**KIRKLEES METROPOLITAN COUNCIL
INVESTMENT & REGENERATION SERVICE**

**DELEGATED DECISION FOR DISCHARGE OF CONDITION A.4 -
NOTIFICATION OF A PROPOSED ENLARGEMENT TO DWELLINGHOUSE**

Reference no.	2021/HH/91524/E
Site Address	60, Bennett Lane, Dewsbury, WF12 7DY
Description	The proposal is for erection of single storey rear extension. The extension projects 5m beyond the rear wall of the original dwellinghouse. The maximum height of the extension is 4m, the height of the eaves of the extension is 3.3m
Recommending Officer	Alice Downham

Date: Apr 2021		Project: New Rear Extension 60 Bennett Lane, Dewsbury		Drawing Title: Block Plan		Drawing No: SK02		Rev	
						Scale: 1:200		Paper Size: A4

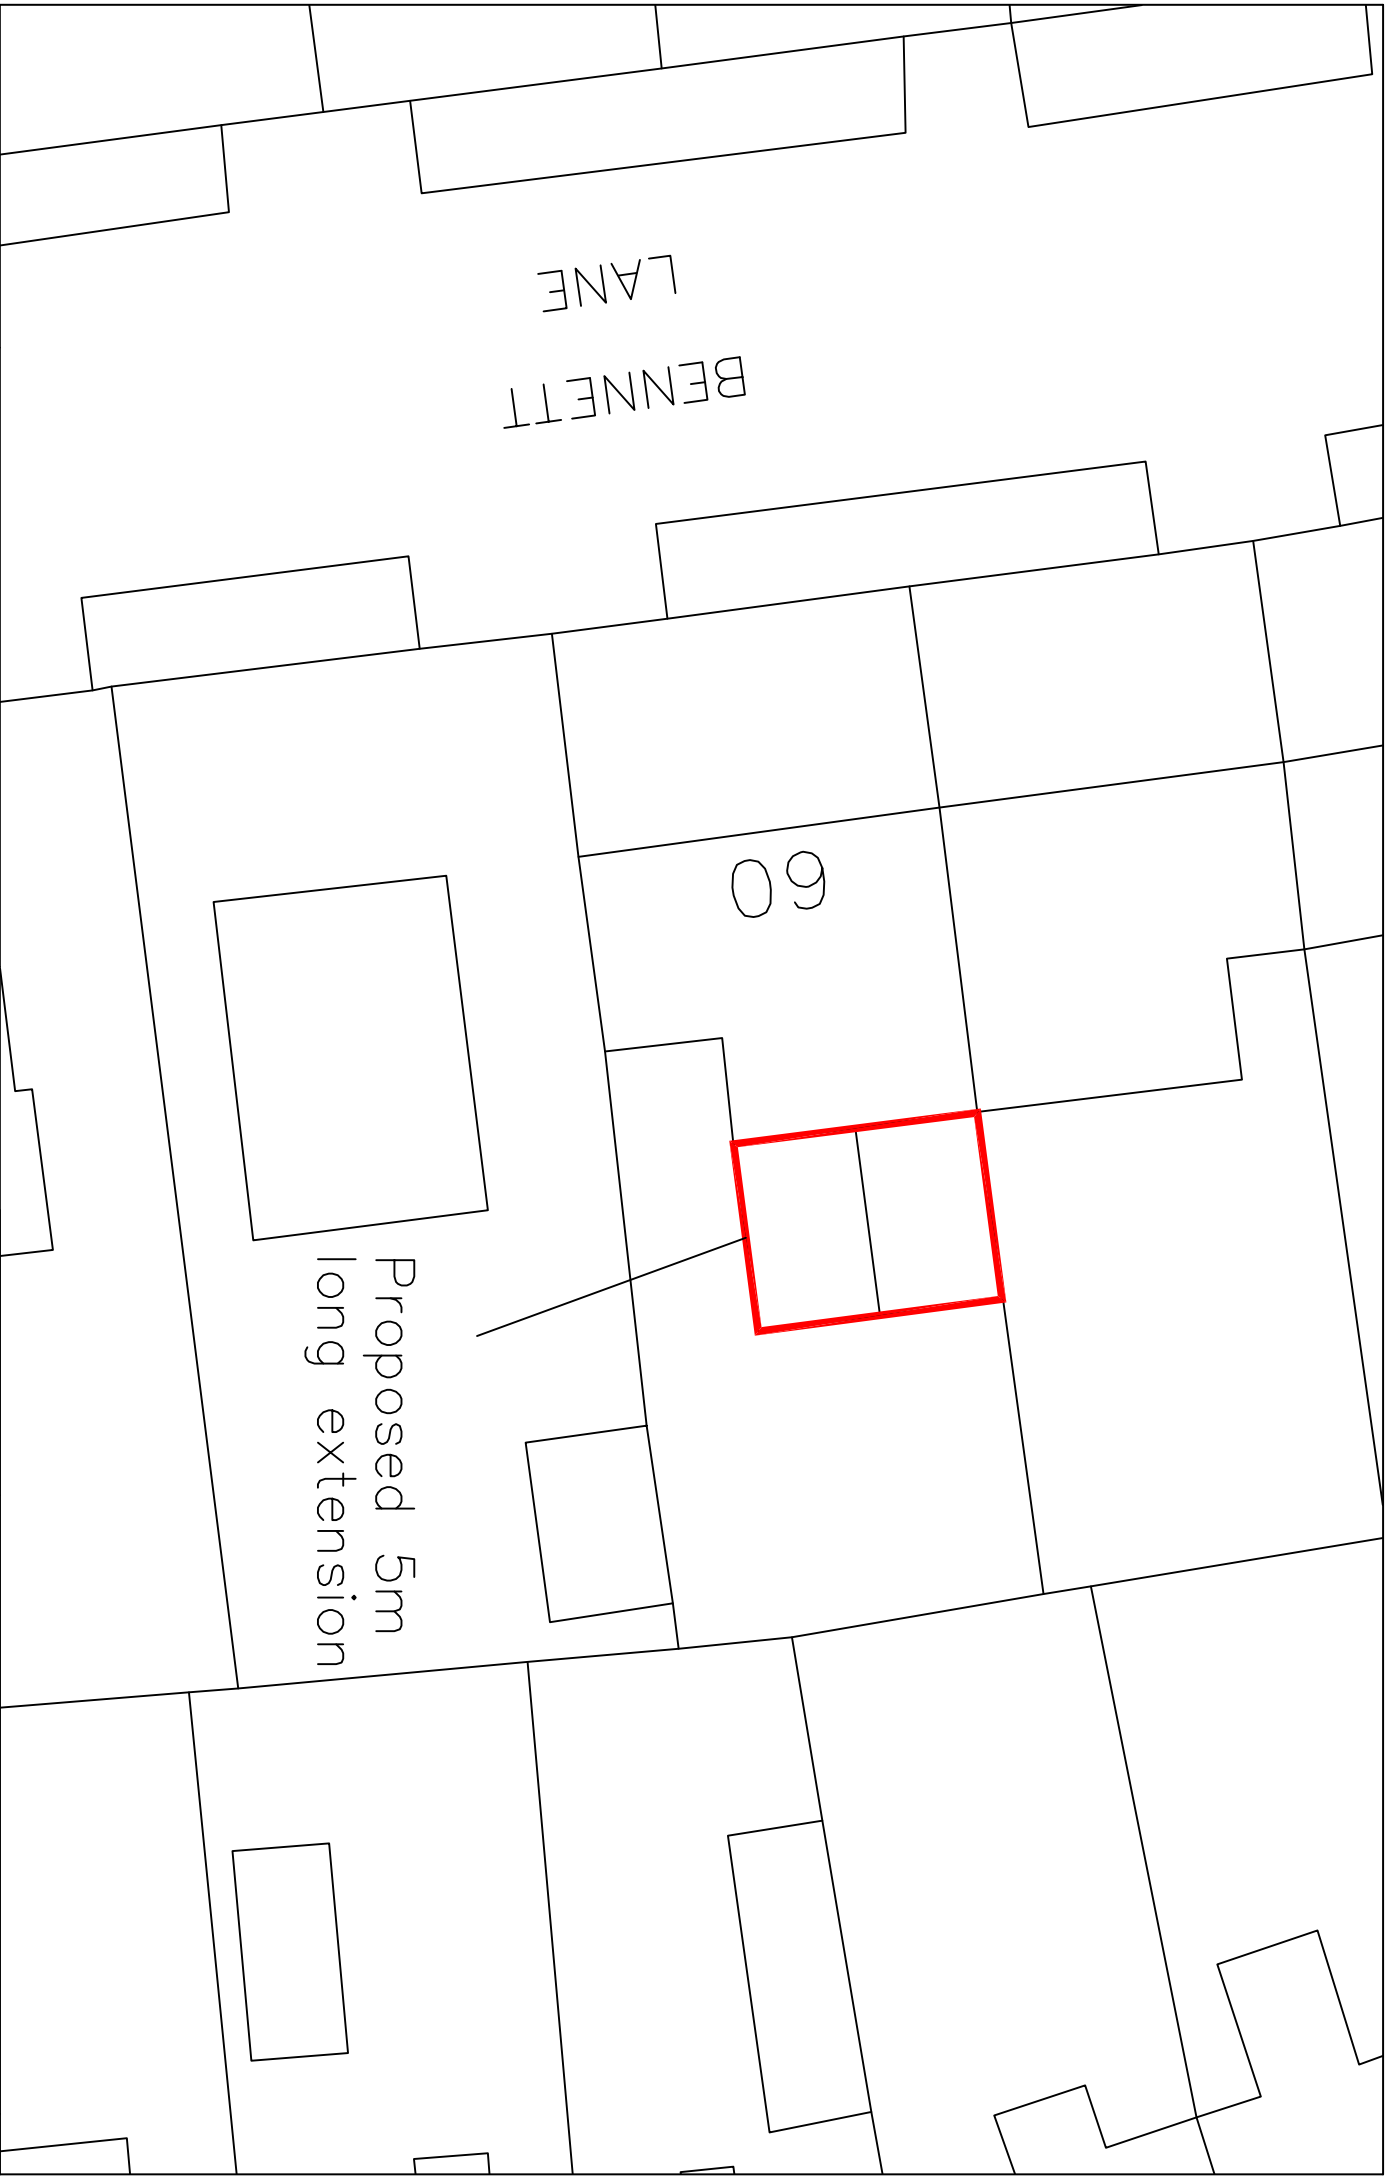
In this case, the proposed extension as shown on the submitted plans is within two metres of the boundary of the curtilage of the dwelling and has an eaves height of greater than three metres. This is contrary to paragraph A.1 (i).

By reason of the location of the proposed extension, which would be located within two metres of the boundary and which would have an eaves height of more than three metres, the proposed extension exceeds the criterion as stated in paragraph A.1 (i) of Class A and therefore cannot be considered to benefit from a general planning permission by virtue of Part 1, Class A of Schedule 2 of the Town and Country Planning (General Permitted Development)(England) Order 2015 (as amended).
